MECKLENBURG COUNTY  
Park and Recreation Department

MEMORANDUM

**RE:** Rezoning Petition #2023-011  
PID# 04521224

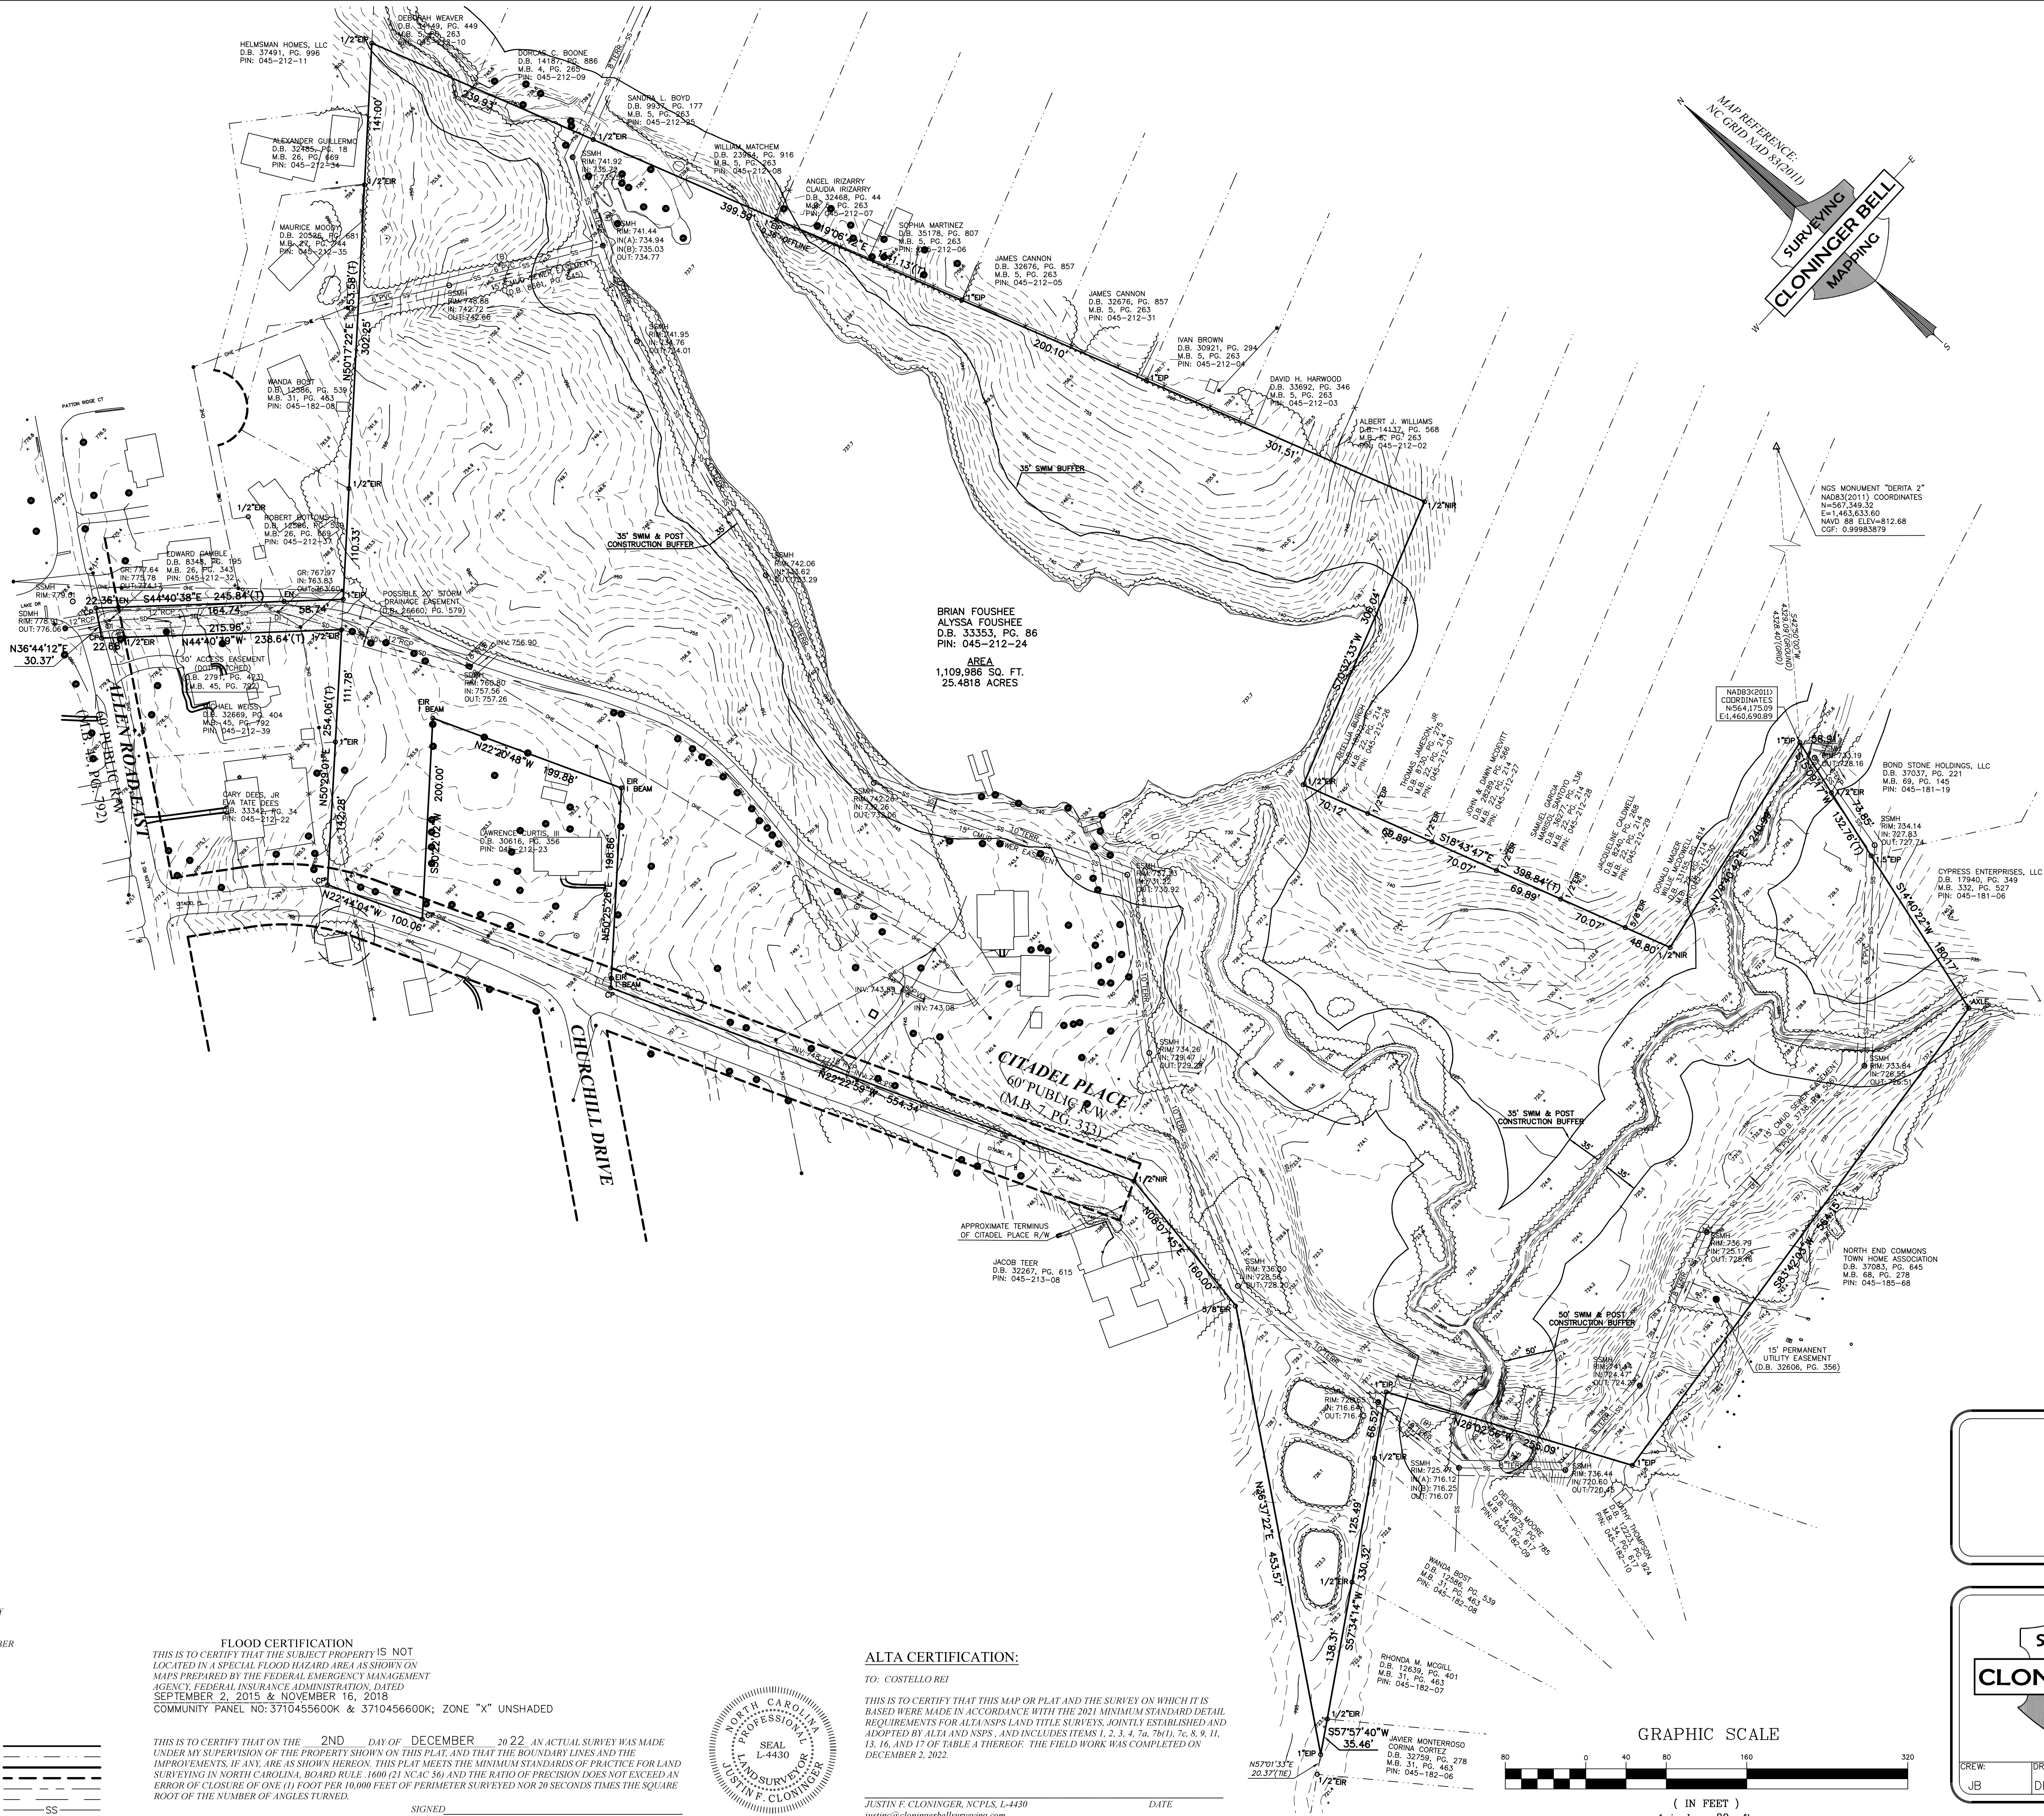
MCPR requested a minimum of **1.25** acres to be dedicated and conveyed to Mecklenburg County for a future neighborhood park. Plans currently show a proposed 1.25 acre parkland dedication area, but this area does not meet the requirements below due to the site topography, parcel layout, and Right of Way access.

This requested park land shall be adjacent to a public right-of-way for access and is conducive for the development of the typical amenities found in a neighborhood park and cannot include tree save parcels or stormwater BMP's.
